Re: Champs Fresh Food
8909 US 401
Fuquay-Varina, NC 27526
BCOM2311-0004

The application and plans for Champs Fresh Food, located at 8909 US-401, Fuquay-Varina, have been reviewed and are disapproved for the following:

Jamie Turlington, REHS
Harnett County Environmental Health
Harnett County Health Department

DWG NO:
D21305
SHEET:
EQ-1

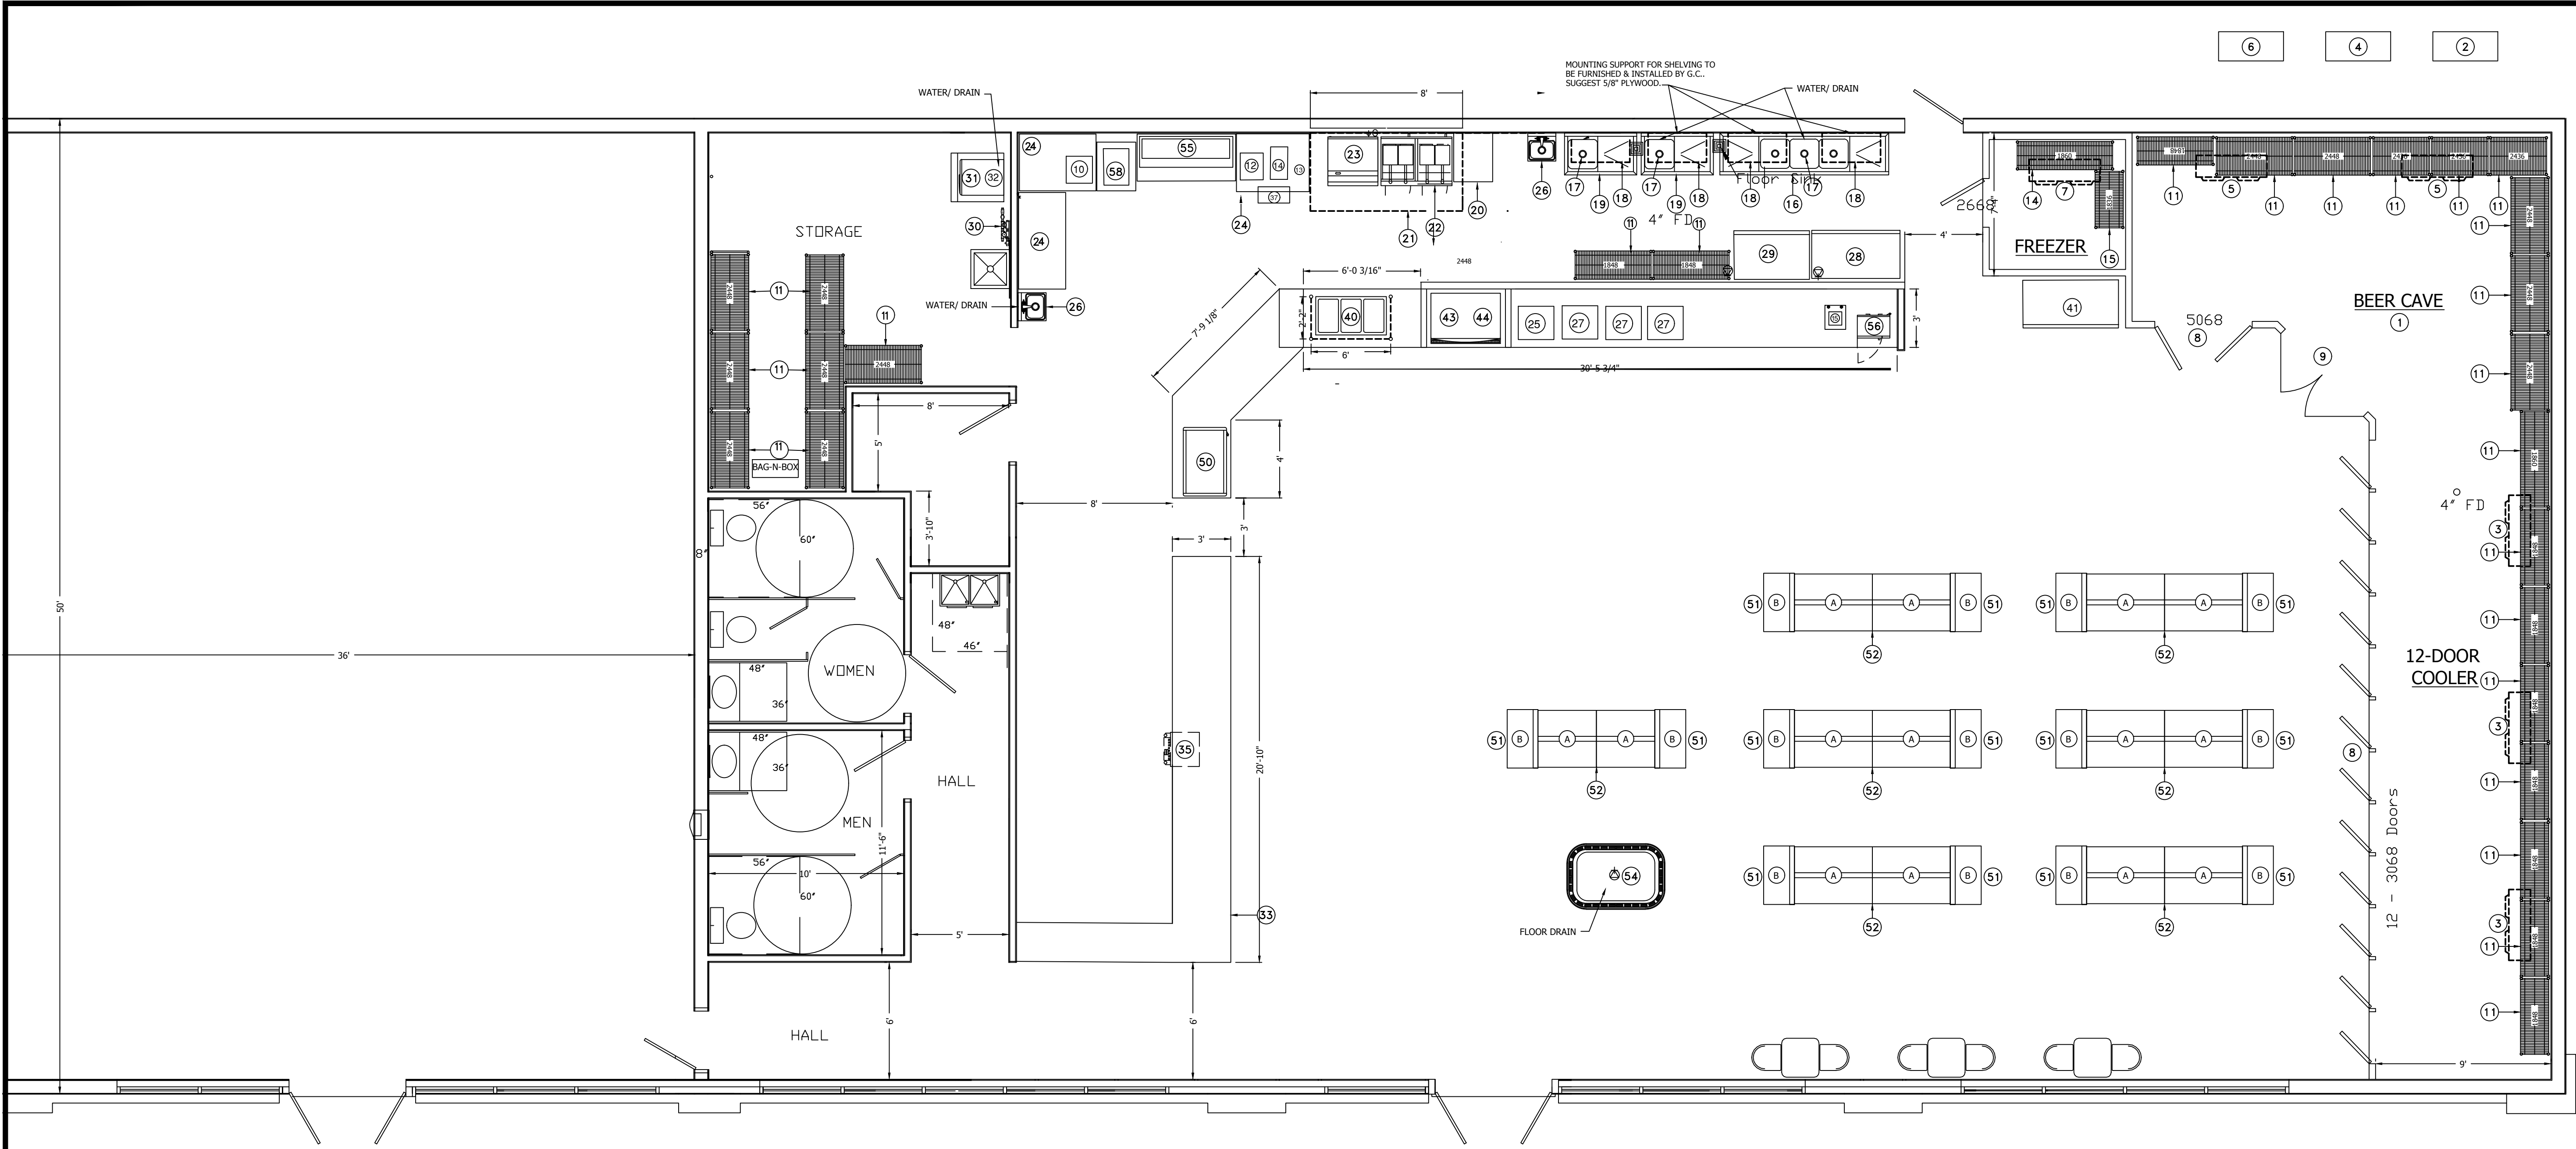
- 3-Provide equipment specification sheets for all food service equipment.
- 4-Provide an additional handsink near the food prep and dishwashing areas.
- 5-Provide additional reach-ins, freezers and refrigerators in the kitchen.

- 6-The plans indicate the public will have access to the walk in freezer in the kitchen. The public must be excluded from areas where food is stored for the kitchen. The freezer cannot have access to the public.

- 7- Indicate the proposed use for the hot holding wells on the front counter and for the heated display case. Describe the type of foods stored in these units.

- 8- Describe proposed use for room off of dry storage room in the back of the kitchen.
- 9-All equipment on plans must have a corresponding equipment specification sheet. Some equipment on plans is not labeled with a number and is not listed on equipment list. It appears there is a sink next to the microwave on the counter. Label and indicate proposed use.

- 10-Describe the barriers on either side of the food prep sink. Permit conditions will be placed on the permit, limiting the operation to only use the prep sink for the preparation of one type of food. The single prep sink will be limited to vegetable prep only and all meats must come in ready to cook.
